Amended Concept Development Application (SSD-9579) for an Over Station Development (OSD) above the new Crows Nest Metro Station including maximum building envelopes, gross floor area, conceptual land uses, car spaces and signage zones.

Submission by Wollstonecraft Precinct Committee (Preliminary)

2.1.11 A-L27 Tower Roof Plant Floor

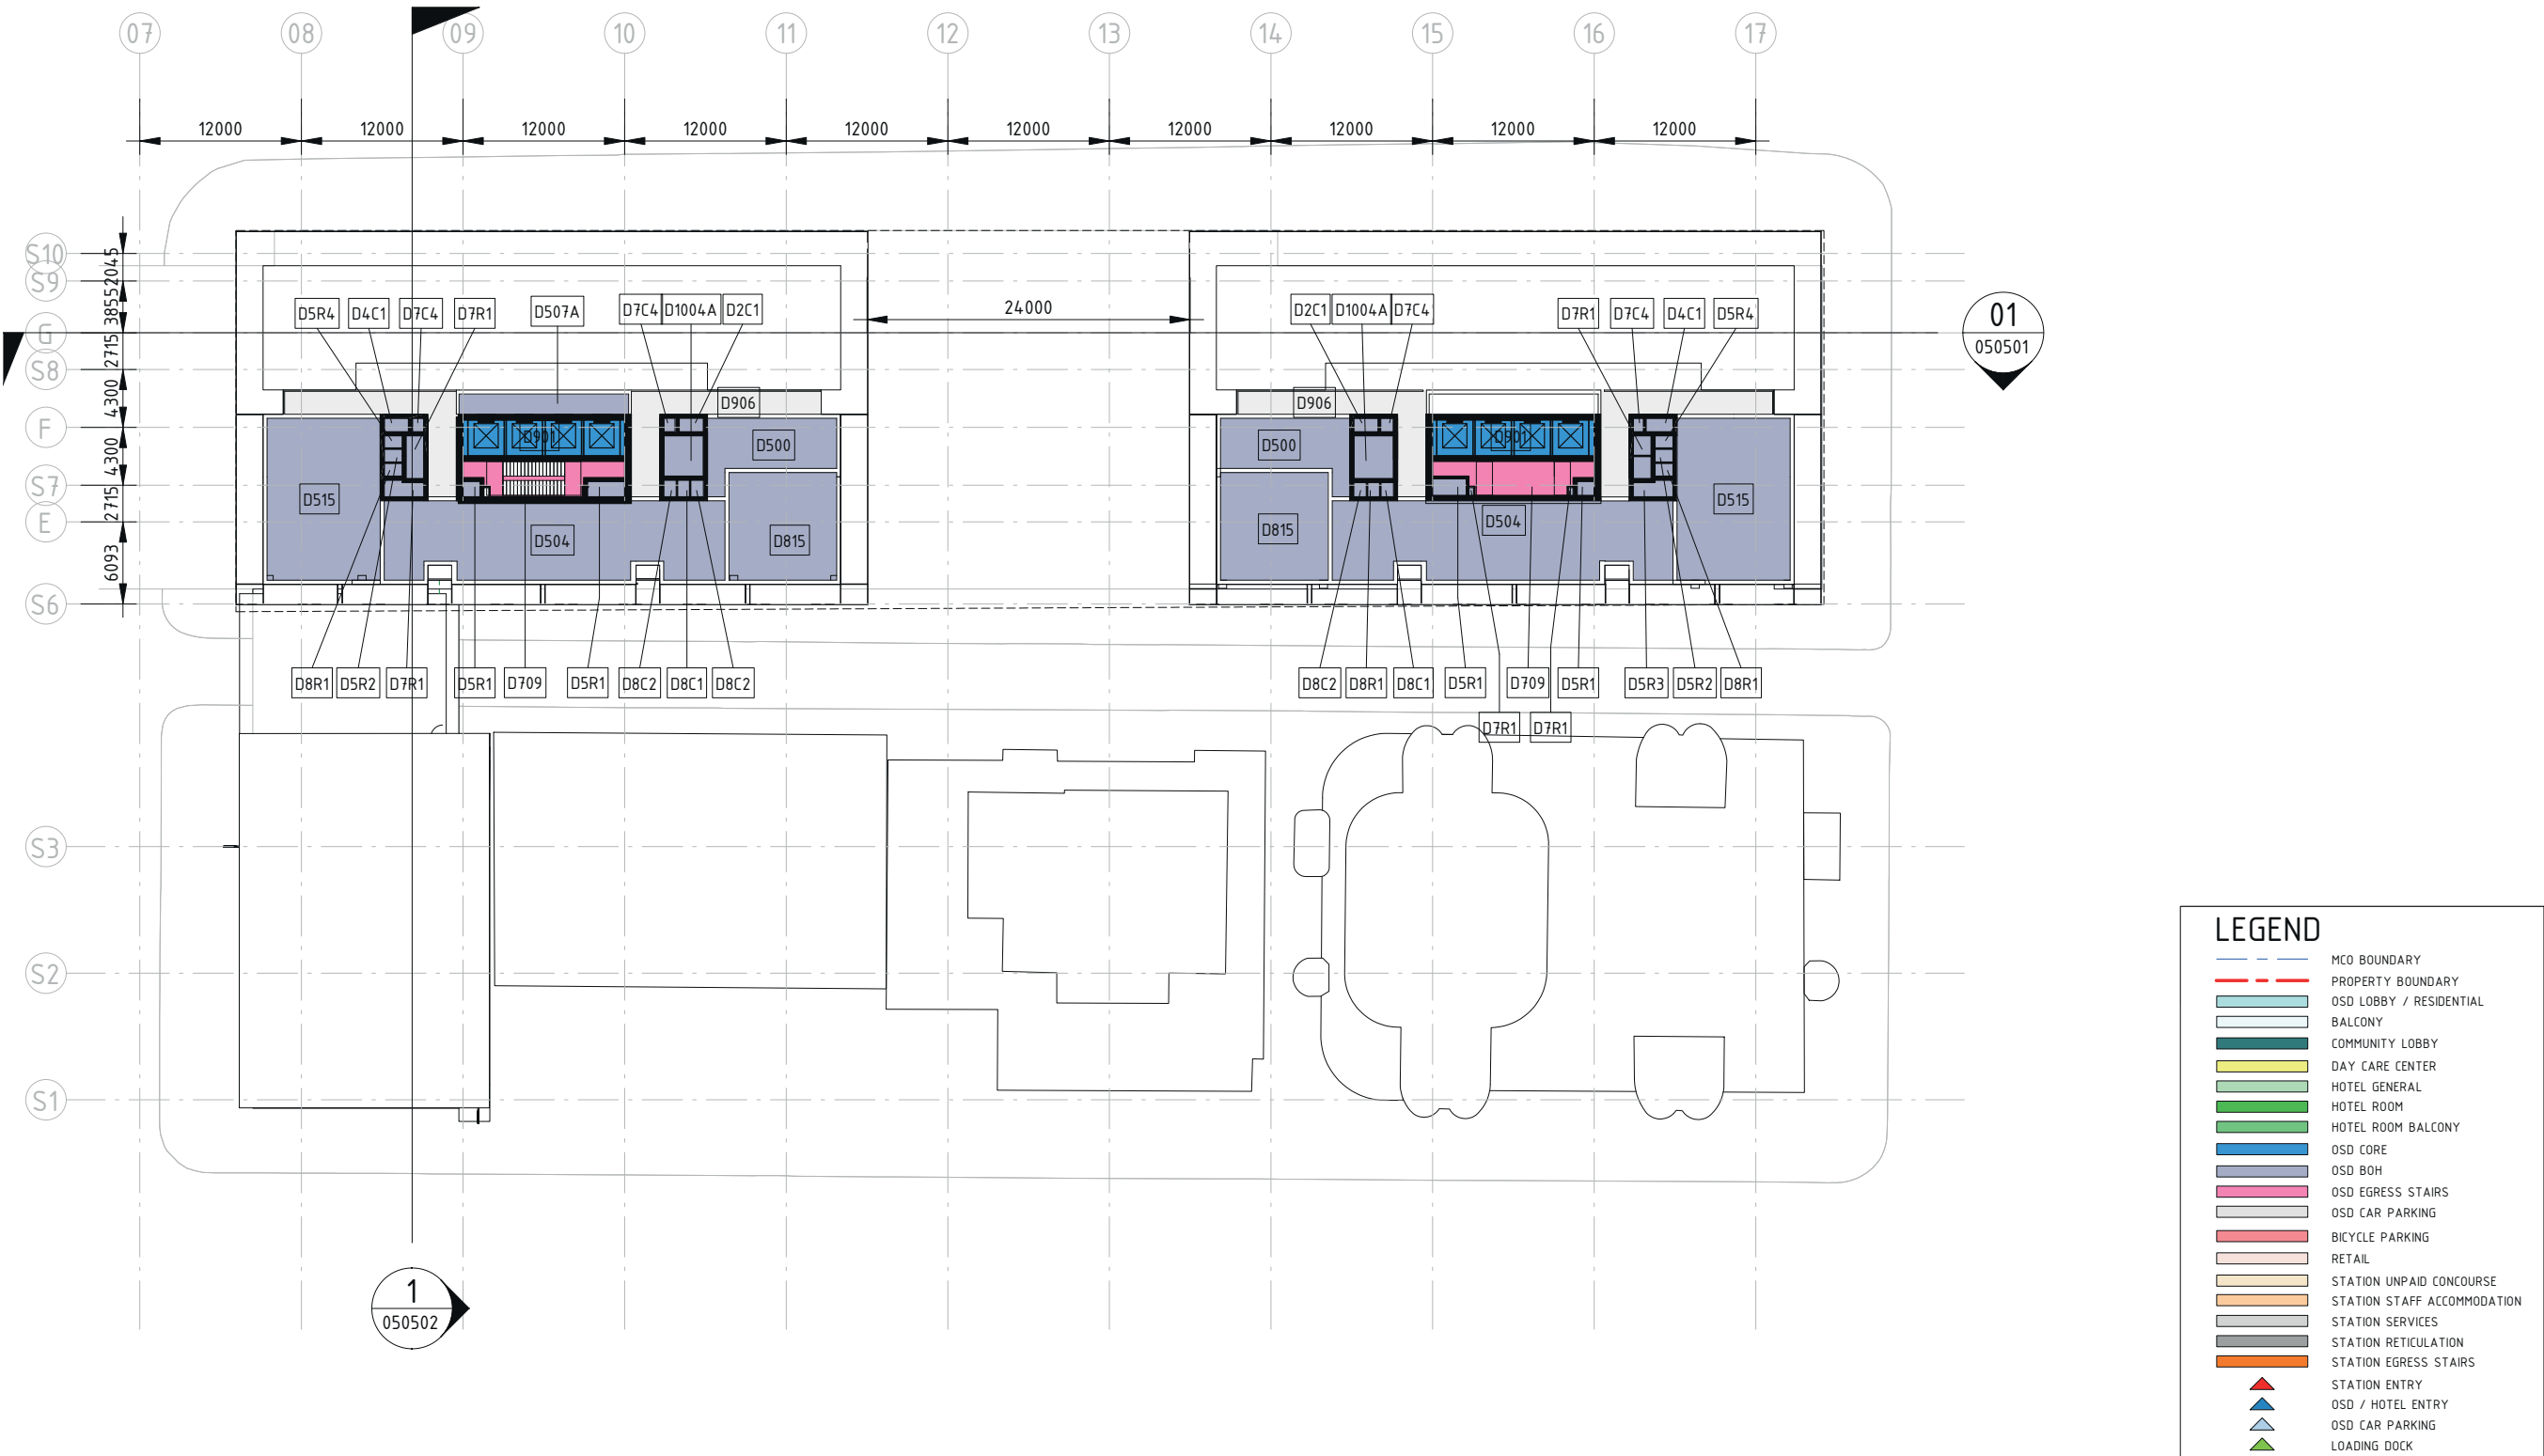
The response from Sydney Metro results in overdevelopment of Site A.

Conclusion: The amount of office space being provided by Sydney Metro is about twice as much as needed for Crows Nest and therefore Building A should be drastically reduced in height leading to less floor space. This would help reduce the over shadowing of the Crows Nest Village which has been ignored in the extensive analysis that has narrowed consideration to only over shadowing on Willoughby road, Ernest Place and Hume St Park. The solution of Sydney Metro to build a massive amount of office space is dated and pre-Covid. Commercial office space demand is and will remain depressed for decades. A better solution would be to both reduce height and also have the government fund job creation initiatives - a recommendation of its own consultants in the draft SLCN 2036 plan.

It is the OSD specifically on Site A and Site B that are contrary to the village atmosphere. Increased bulk and scale with heights to RL180 and RL155 can never be described as being in context with the village. They are just too high and bulky, looking like a box plonked atop the otherwise attractive new entrance to the village. Site C office building above the station eastern entrance makes no sense at all.
